Application for a non-material amendment following a grant of planning permission.

Number	
Suffix	
Property name	Botwellears House, Rear of 25 Botwell Lane, Hayes
Address line 1	Botwellears House, Rear of 25 Botwell Lane
Address line 2	
Address line 3	
Town/city	Hayes
Postcode	UB3 2AB
Description of site location must be completed if postcode is not known:	
Easting (x)	509777
Northing (y)	179911
Description

To make non material amendment to approved application 1644/APP/2020/1061 approved on 7 July 2020. The proposal is to relocate bin stores for Botwellears House tenants to the rear of 23 Botwell Lane (also owned by Mt Sabaratnam who owns Botwellears House). The land has been levelled and concreted, as have the access roads owned by the nearby Church. This would mean that there is no need to alter Flat B's ground floor window, or insert a second gate in the wall bounding Flat B's garden. The owner also wishes to remove the existing garage door and substitute brickwork to match existing.

Drawing Title
Proposed North & South Elevations
No change to N, balcony proposed SW

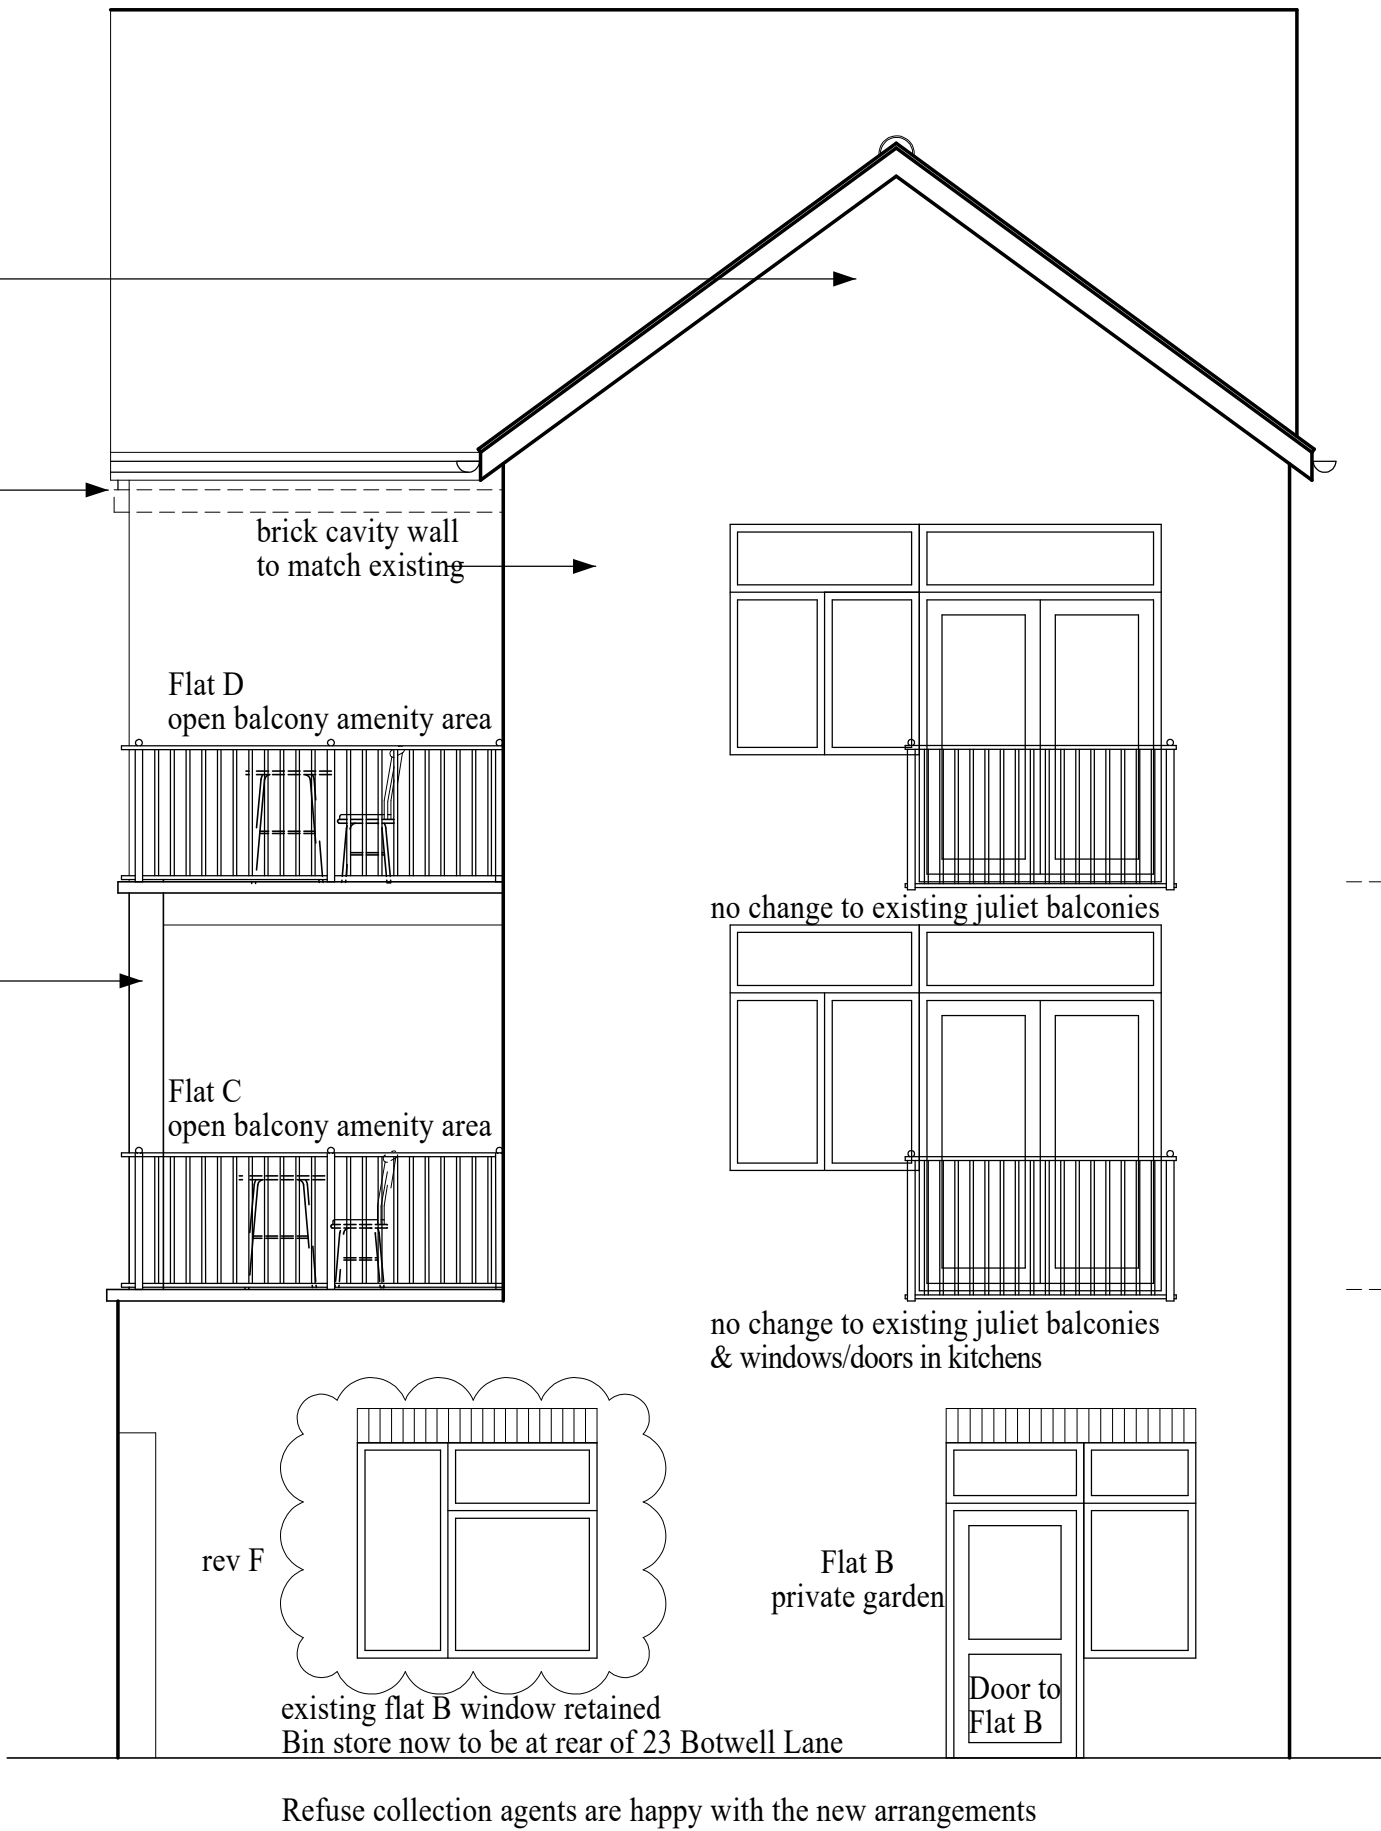
Amend the bin and bike store locations to be at the rear of 23 Botwell Lane as welcomed in the last year by Hillingdon Refuse Collectors. Consequently, Flat B garden need not be reduced in size and Flat B south facing window to the bedroom in Flat B can remain where it is. The proposed new west facing window can be omitted, and the owner wishes to remove the existing garage door on the west elevation and replace it with brick work to match the remainder of Botwellears House.
